***MODIFICATION REQUEST:
Westmead Millennium Institute at the
Westmead Health Campus
(MP10_0050 MOD 2)***

- Modification to the access arrangements, detailed design, construction work hours, ESD initiatives and travel demand requirements for the Westmead Millennium Institute.

Director-General's
Environmental Assessment Report
Section 75W of the
Environmental Planning and Assessment Act
1979

December 2013

EAST ELEVATION

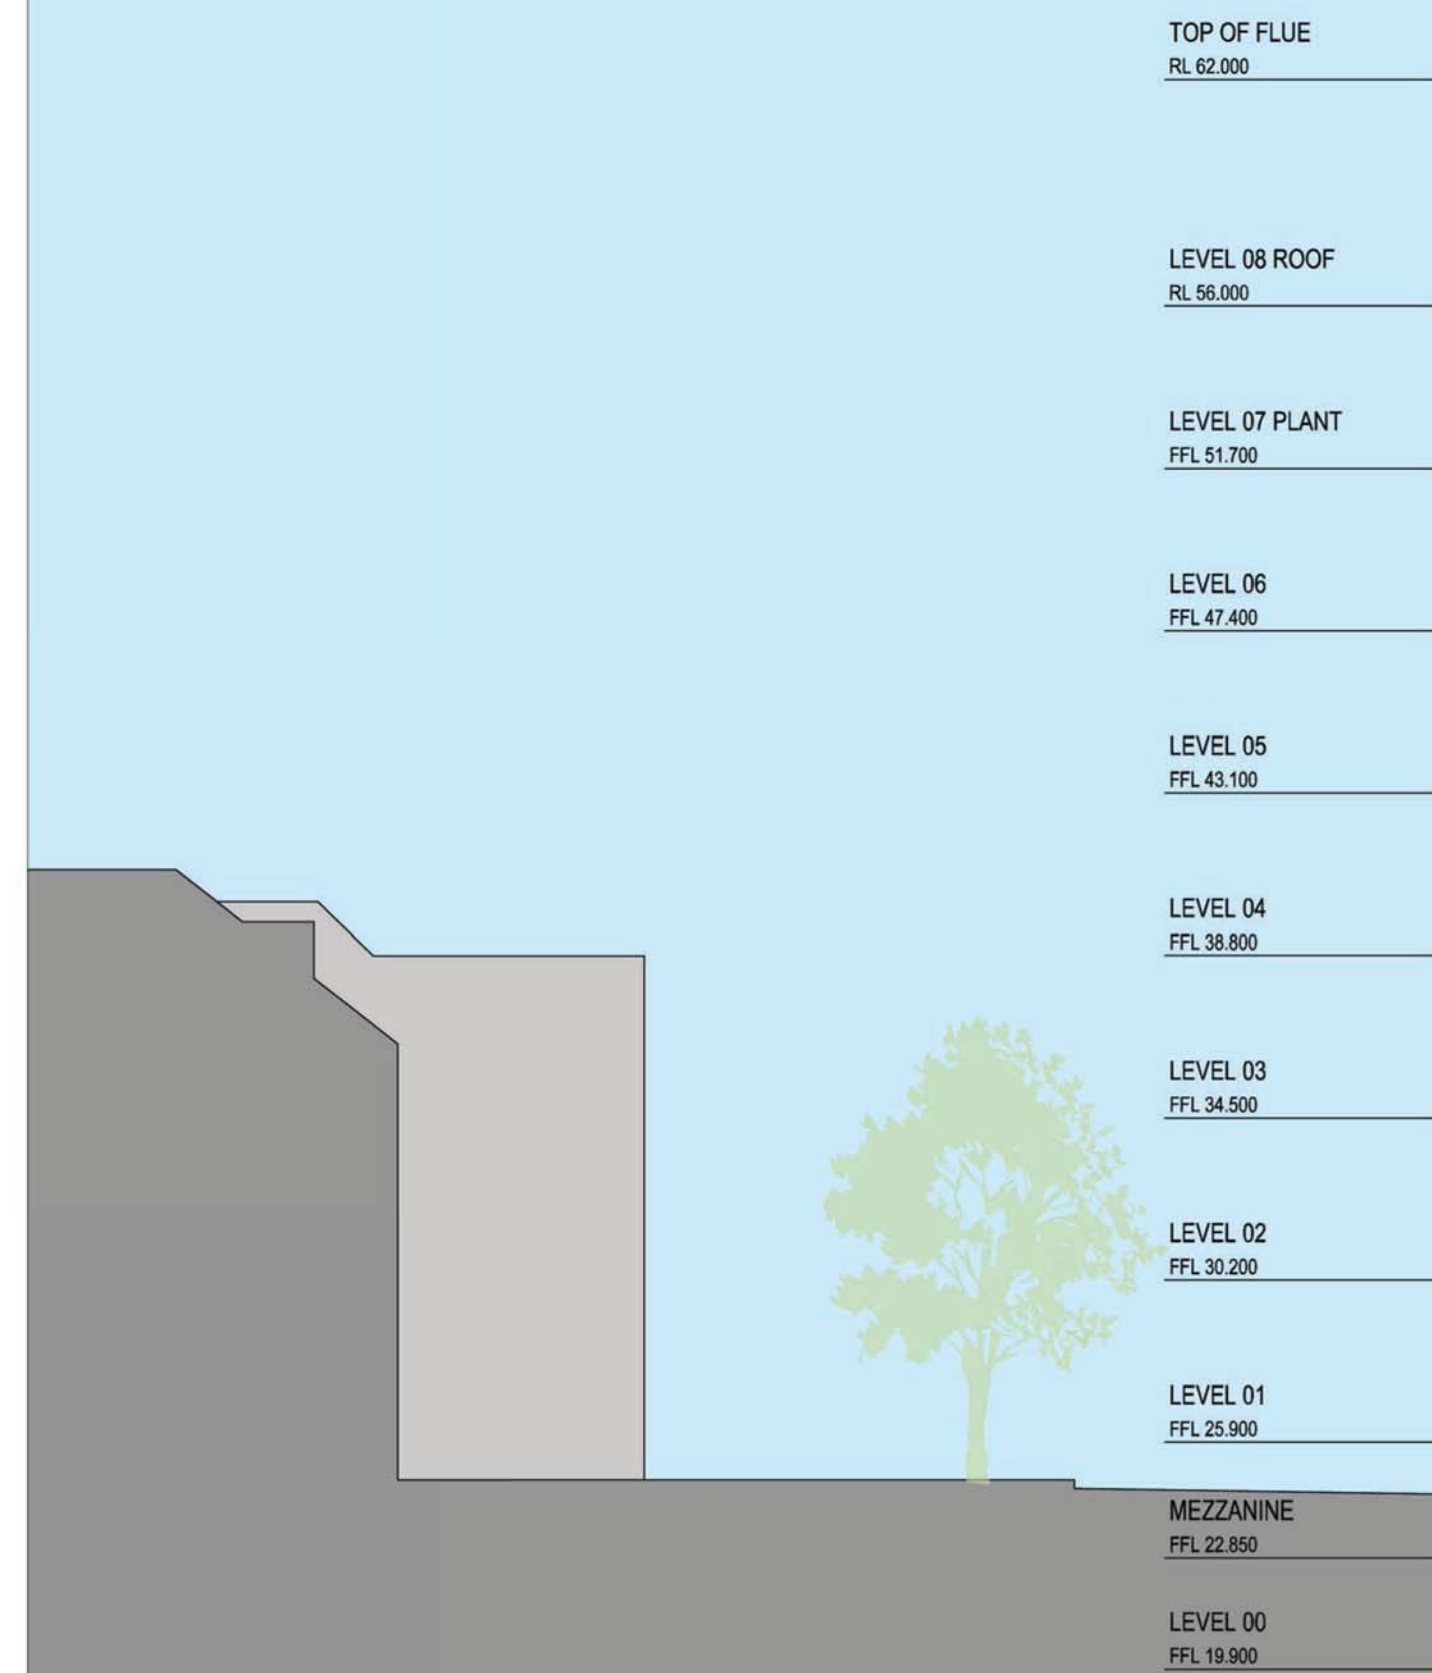
The configuration of the approved entry ramp from Hawkesbury Road will need to be changed to address the significant difference in level between the footpath and the main entry. A number of solutions have been considered including: extending a ramp across the footpath which would exceed council's gradient requirements; and retaining the existing arrangement by lowering the entire building, which would have significant implications for the overall design and layout of the building.

The preferred solution involves extending a ramp (1 in 40 gradient) in a north-south direction along the south-eastern corner of the building with an adjacent set of steps connected between the footpath and the main entrance level. The department notes this will involve removal of a planter box in front of the building. The department does not consider this will have any significant adverse impact on the appearance of the building as the main planter box on the western side of the entry will be retained to soften the visual impact along the street edge.

The department considers the proposed access arrangement to be acceptable.

FLOOR PLAN
LEVEL 00 - LOWER GROUND

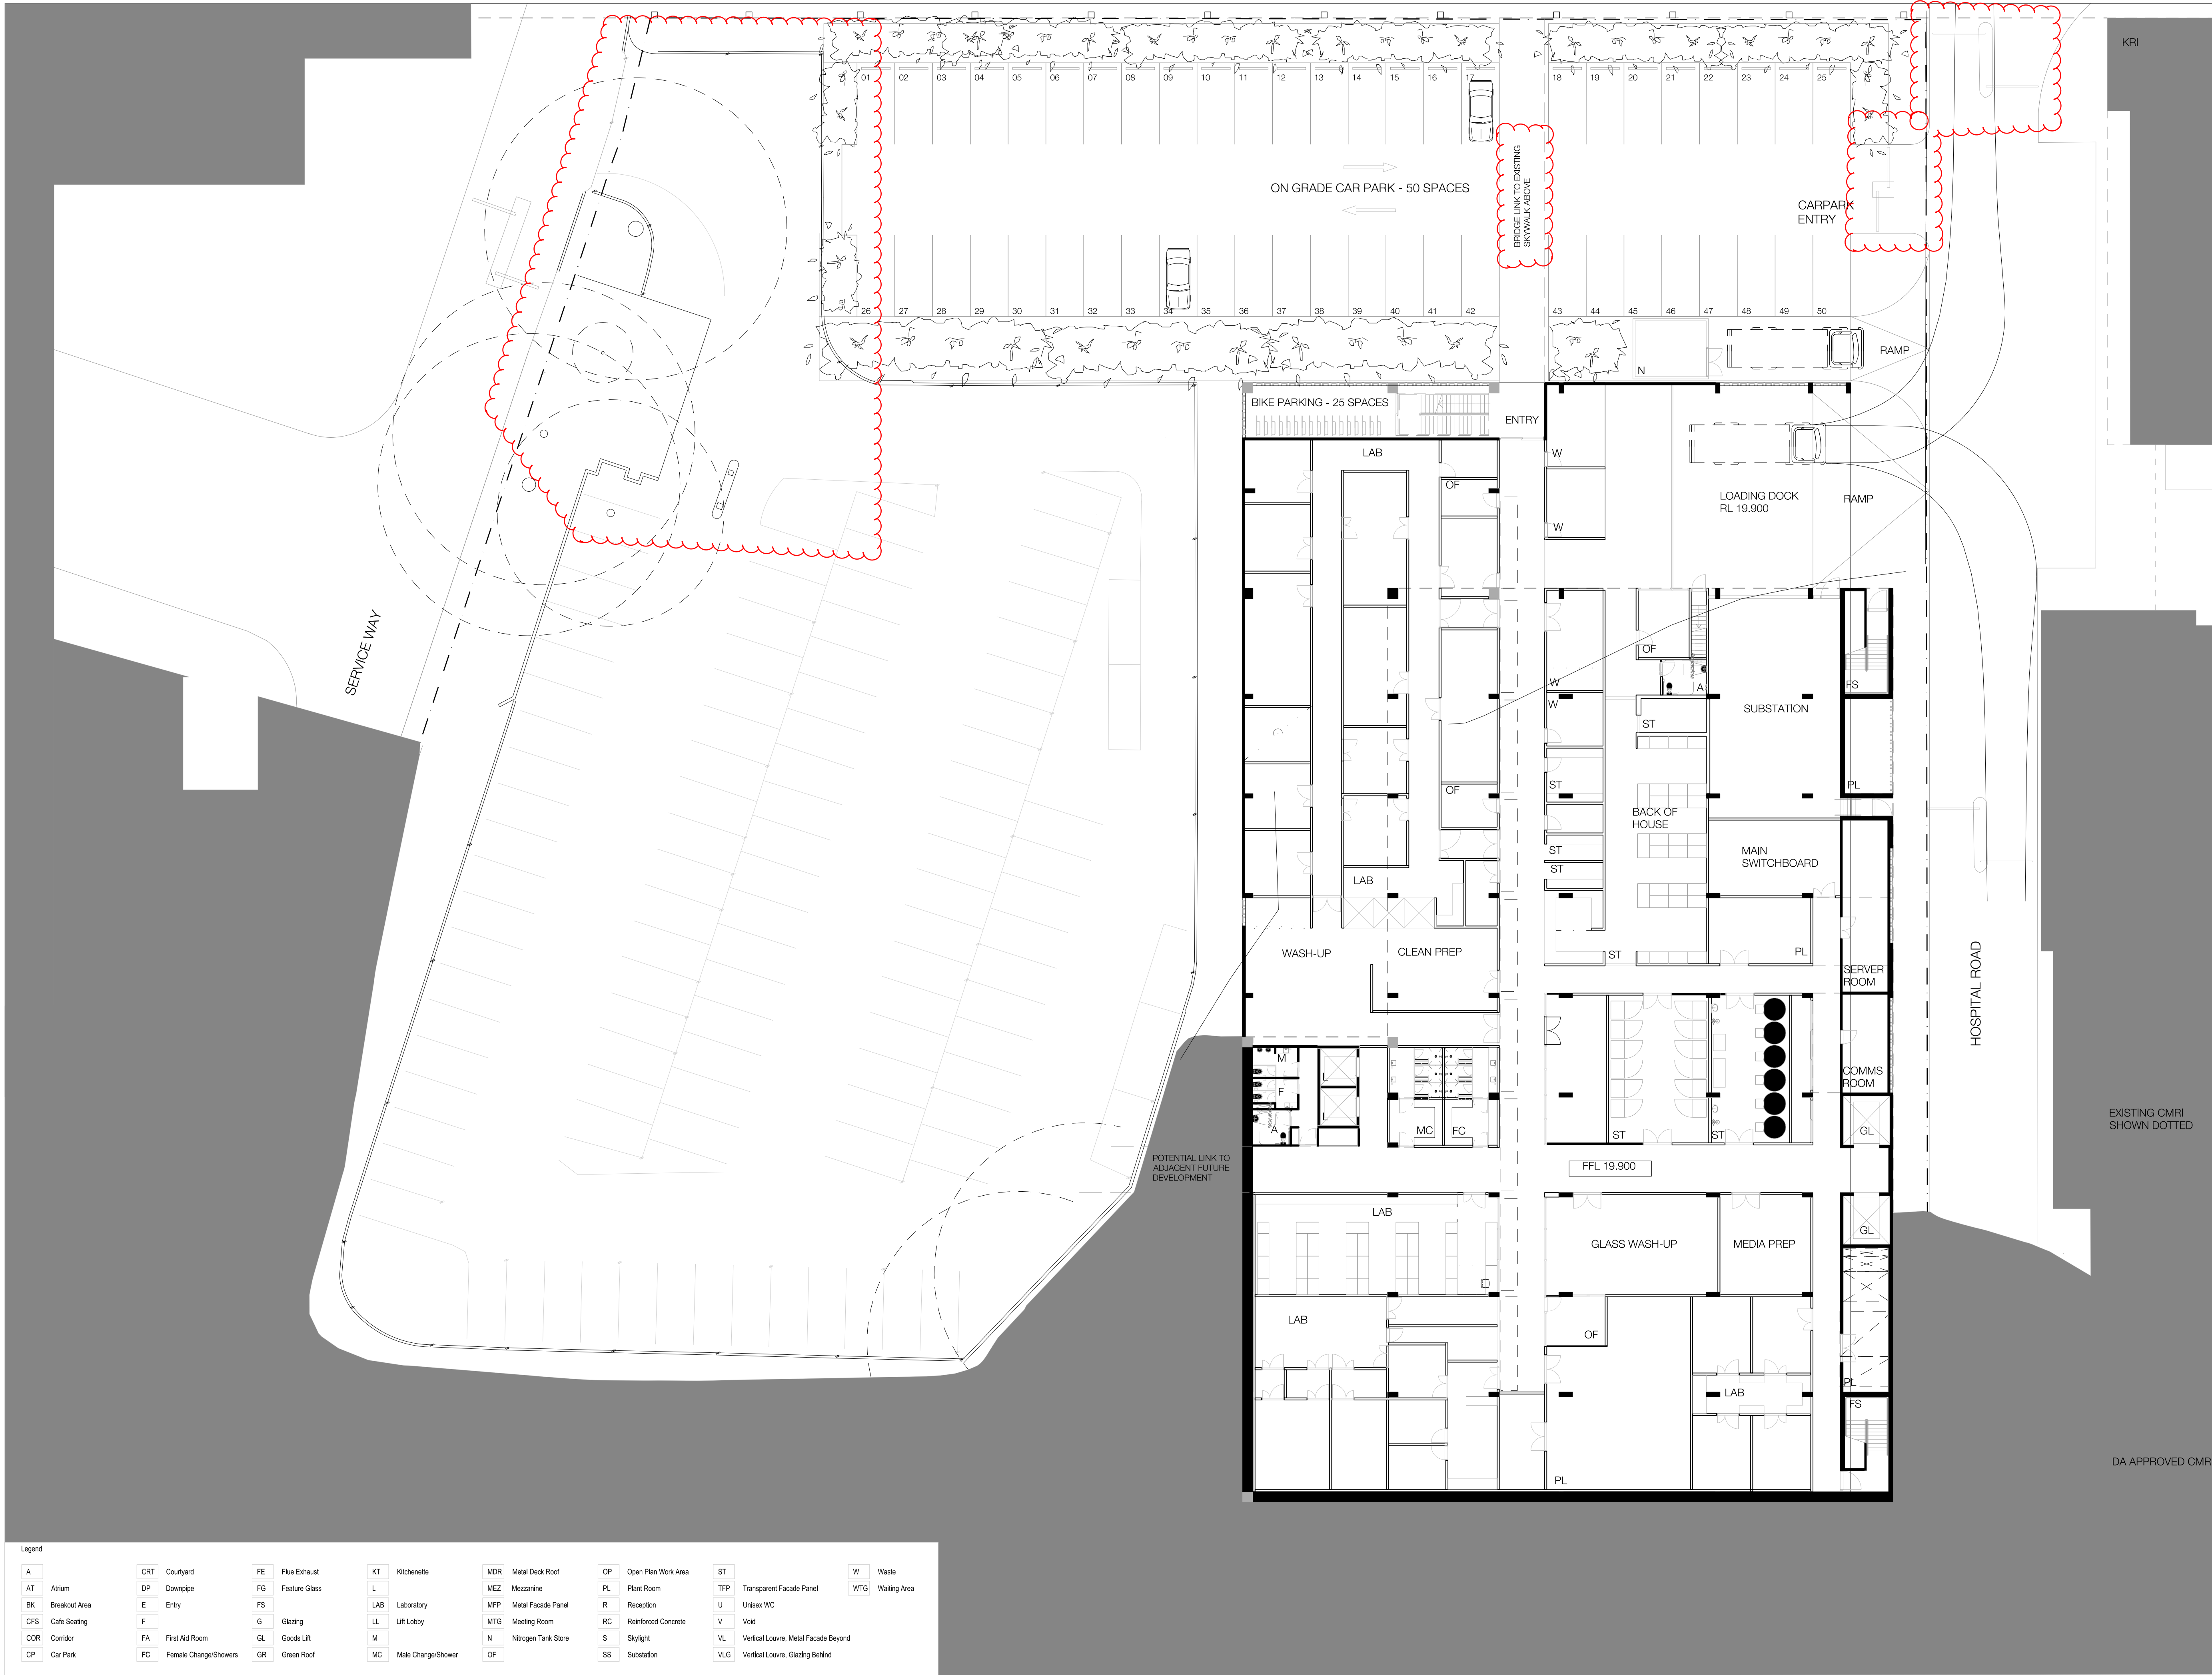
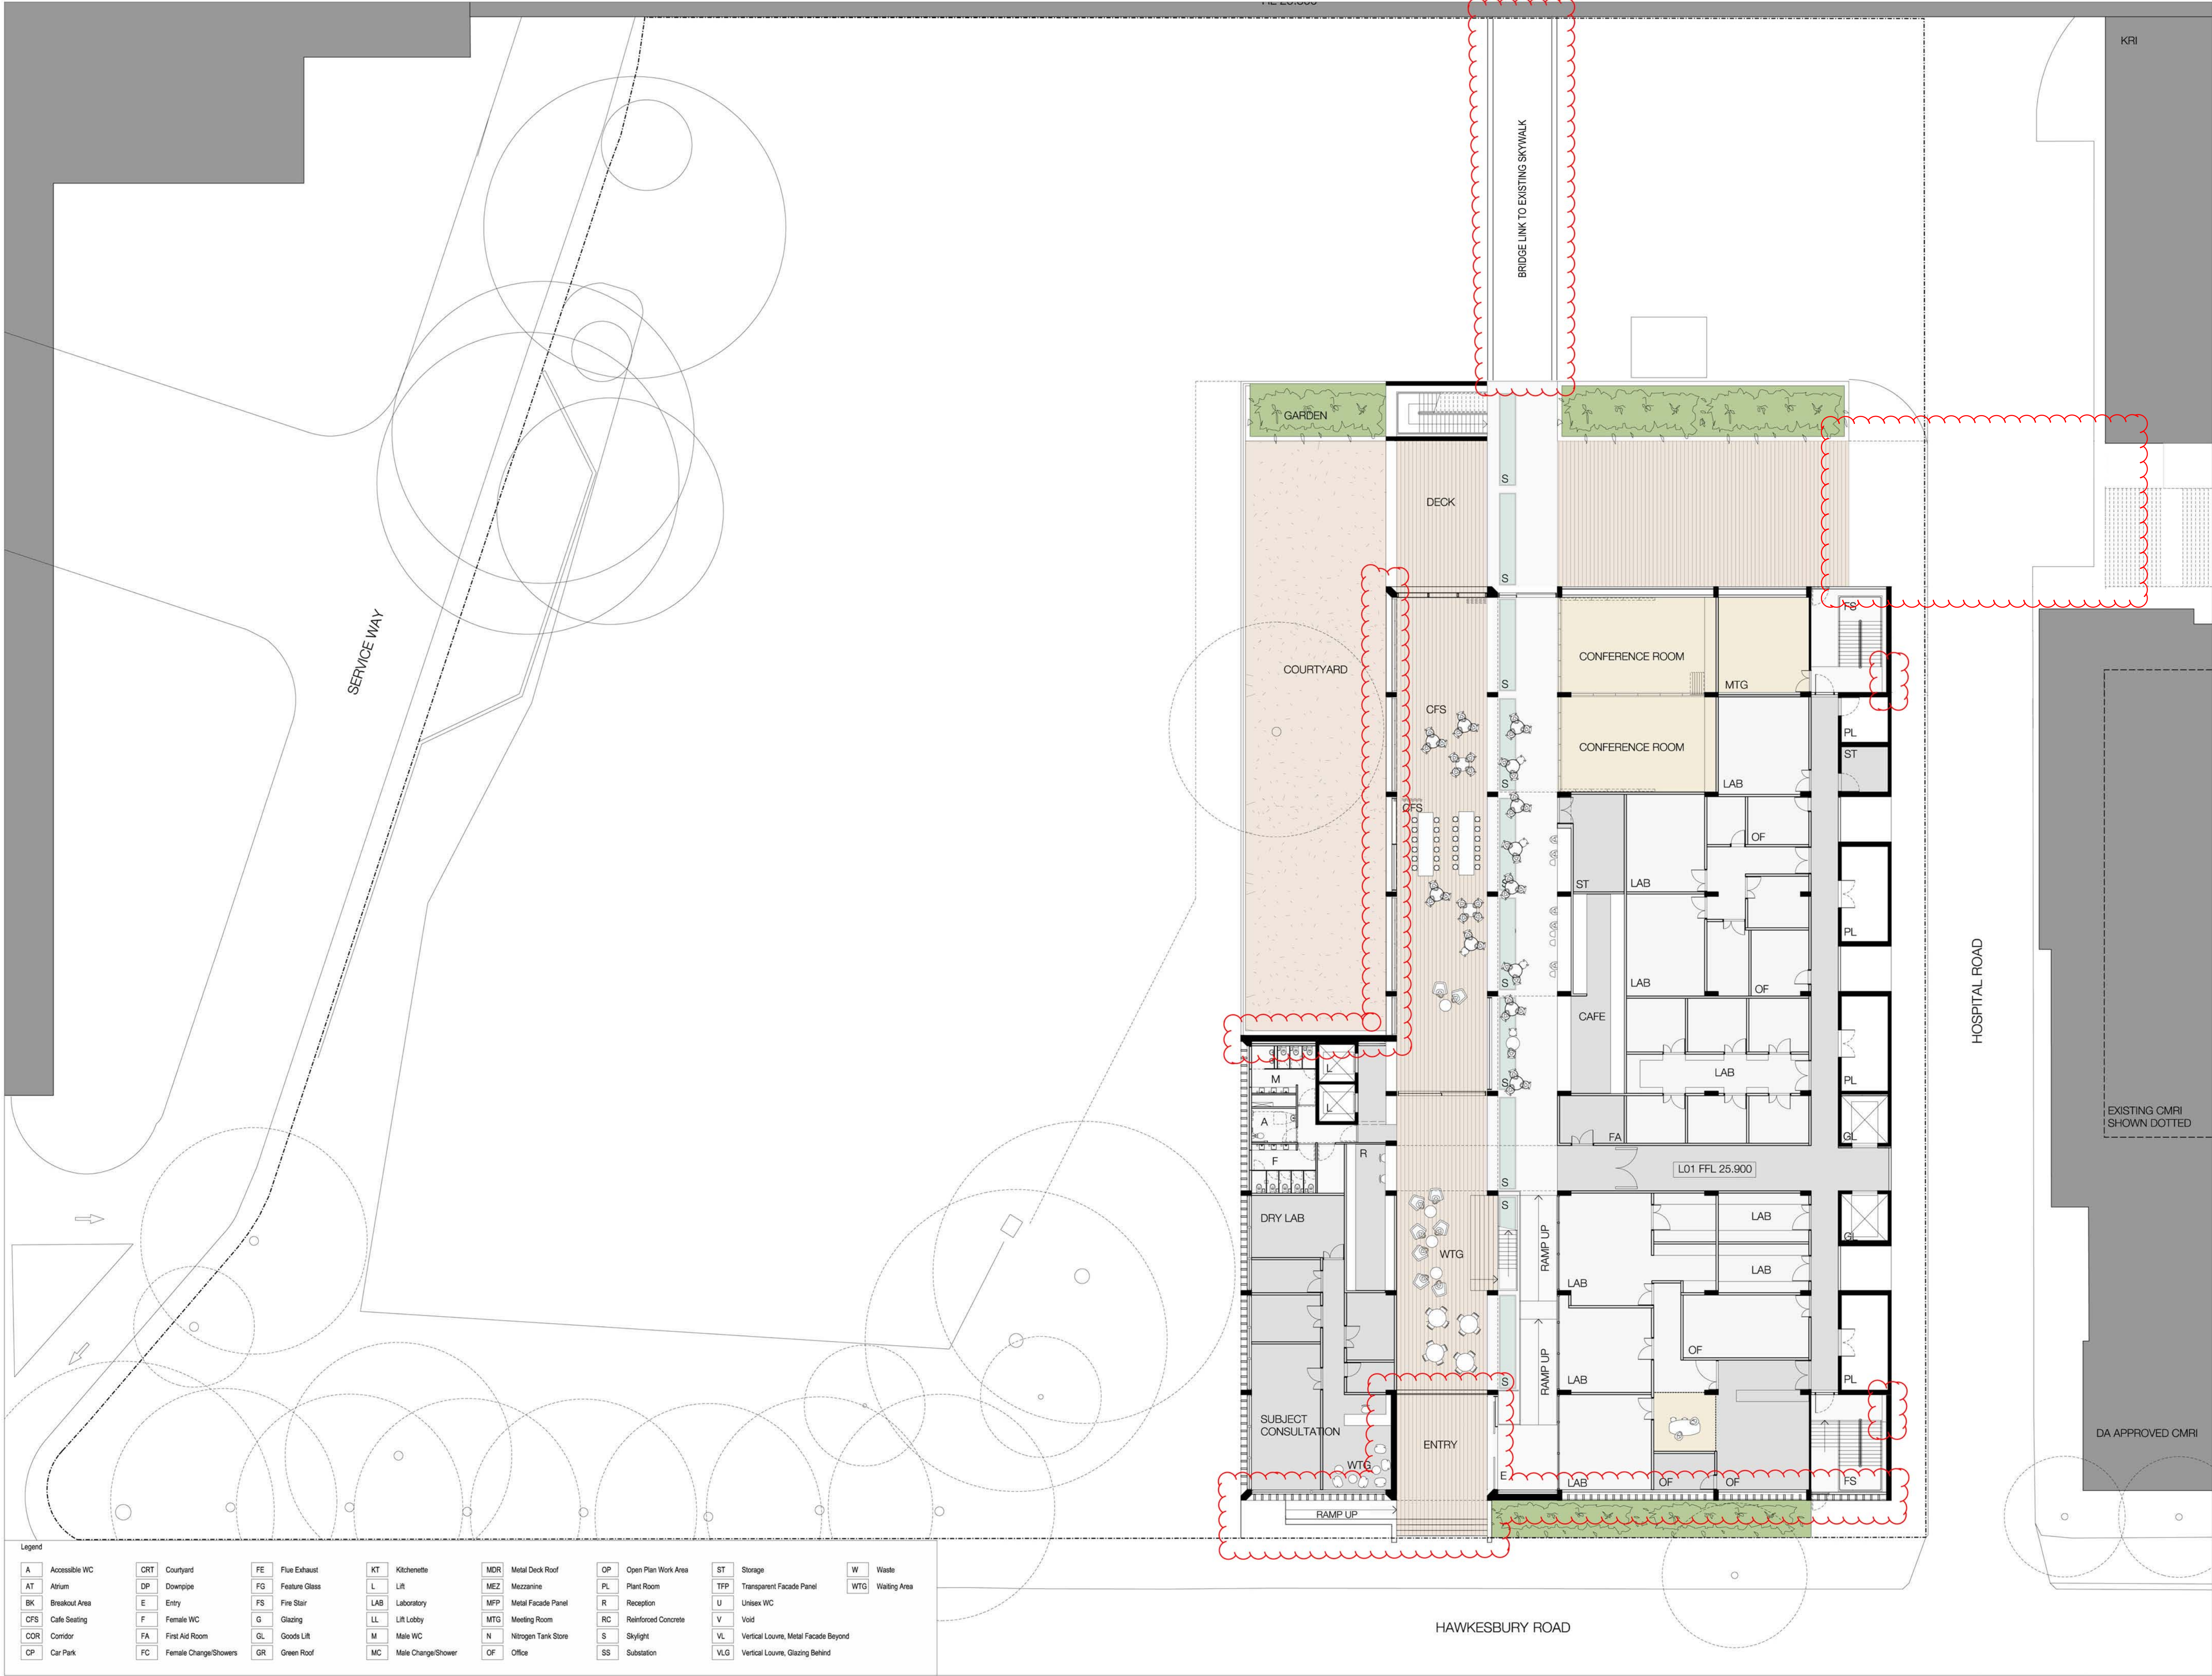
The approved vehicular access to the car park for WMI staff and visitors will involve ingress via the Westmead Hospital car park internal access road to the southwest, and egress via Hospital Road to the northeast adjacent to the CMRI. This arrangement requires entry through two boom gates and the Westmead Hospital controlled car park unrelated to WMI. On departing the car park, WMI staff and visitors would have access to the controlled Children's Hospital car park. It is now proposed to create a combined ingress/egress via Hospital Road to avoid the need for staff and visitors to the WMI to enter an adjacent controlled car park.

To accommodate the combined ingress/egress from Hospital Road, the existing boom gate on Hospital Road will be relocated further north to avoid the adjacent controlled Children's Hospital car park. The proponent's traffic consultant has advised there is sufficient space beyond the car park entry to relocate the boom gate without impacting access to other buildings or car parks to the north. The proposed location of the relocated boom gate will be closer to intersection points along Hospital Road, however, in view of the low vehicle speeds there is not likely to be any adverse impact. It is recommended that appropriate signage be installed to ensure vehicles queuing at the relocated boom gate remain clear of any intersections to maintain vehicle safety.

The proposed changes to the approved vehicular access arrangements are therefore acceptable.
